Your ref: SSD-9667 MOD 2
File no: MC-18-00004

SSD-9667-Mod-2- Request for advice – Light horse Interchange Business Hub

Blacktown Council's submission to SSD-9667 MOD 2 – Light horse Interchange Business Hub

Figure 3: Subdivision Plan

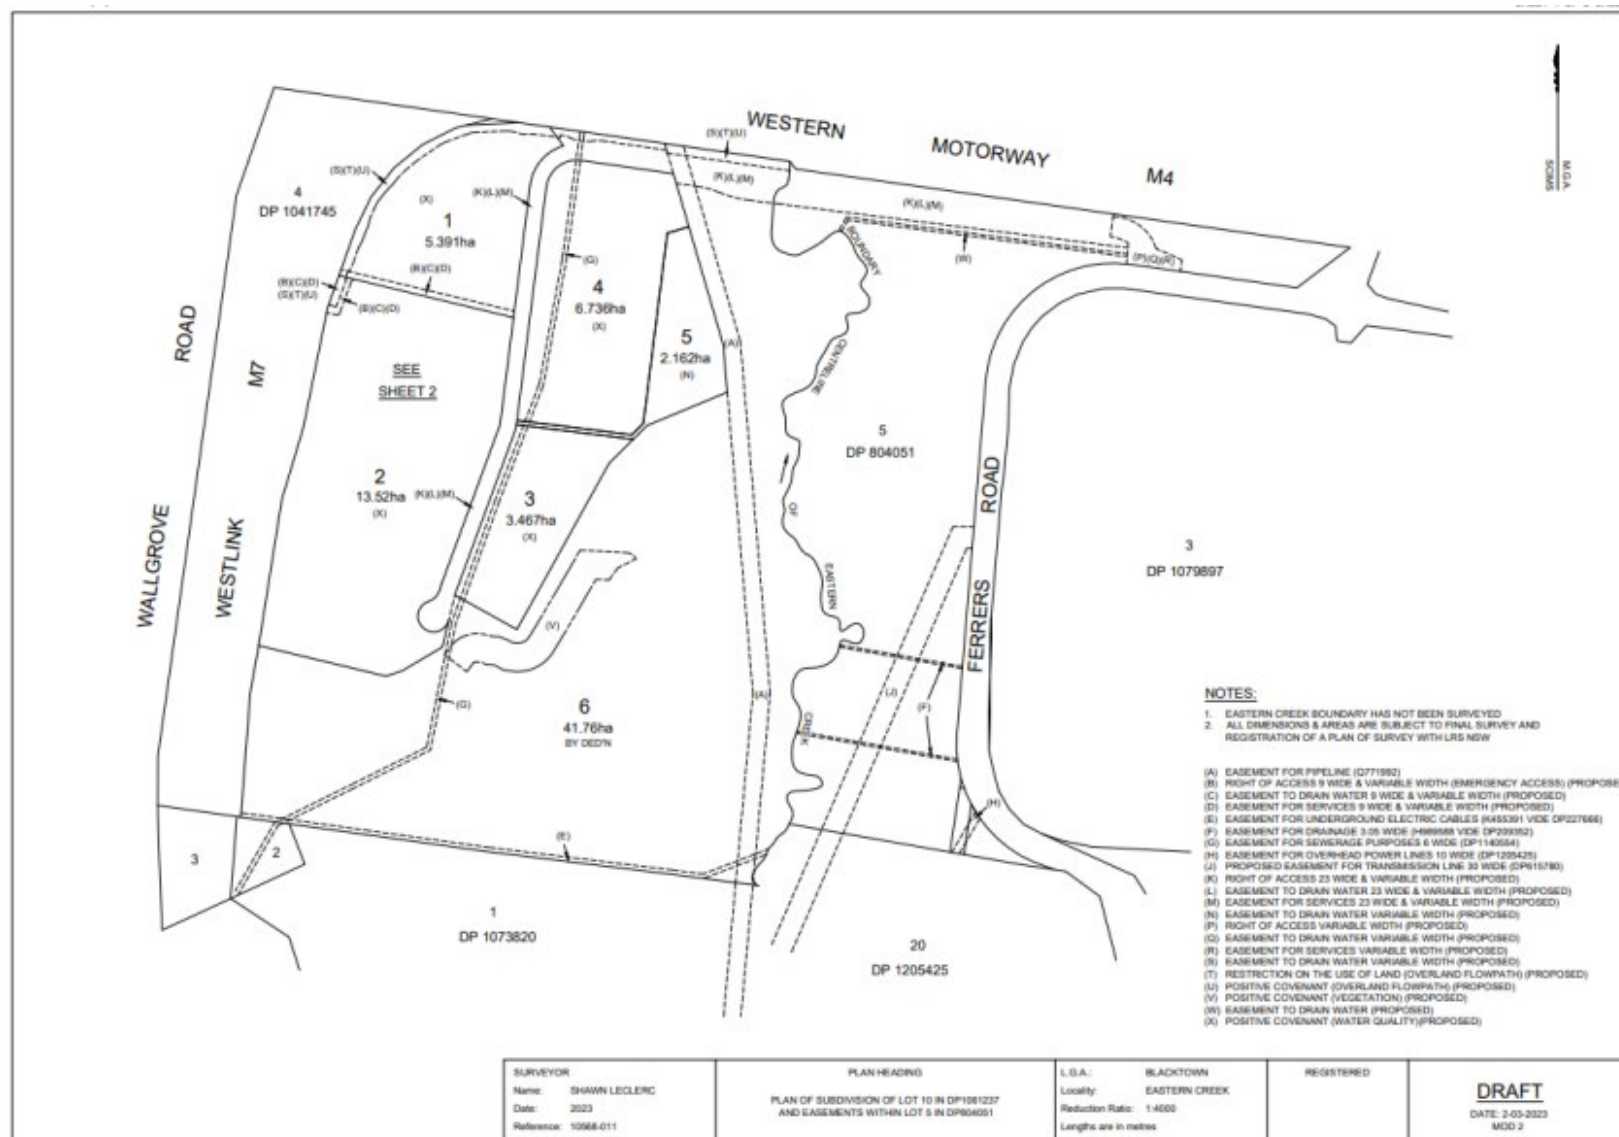
- a. Concerns are raised regarding the visual impact at Viewpoint 6 location. Landscape Plan Dwg 106 is not included in the Landscape drawing set. Please provide this for review.
- b. Please confirm bulk earthwork levels for proposed lot 2. Section 6.6.2 of the MOD report states there will be a 1.18m increase to the finished floor levels however Viewpoint 1 of the Visual Impact Assessment indicates a noticeably taller warehouse structure which clears the tree canopy level. It is to be noted that this MOD does not seek any increases to building heights.
- c. Provide pedestrian access to the container café, the present configuration relies on driveways and emergency access roads for pedestrian entry and exit.
- d. The container café represents the only food and drink amenity serving the entire site, it is encouraged to provide pedestrian links
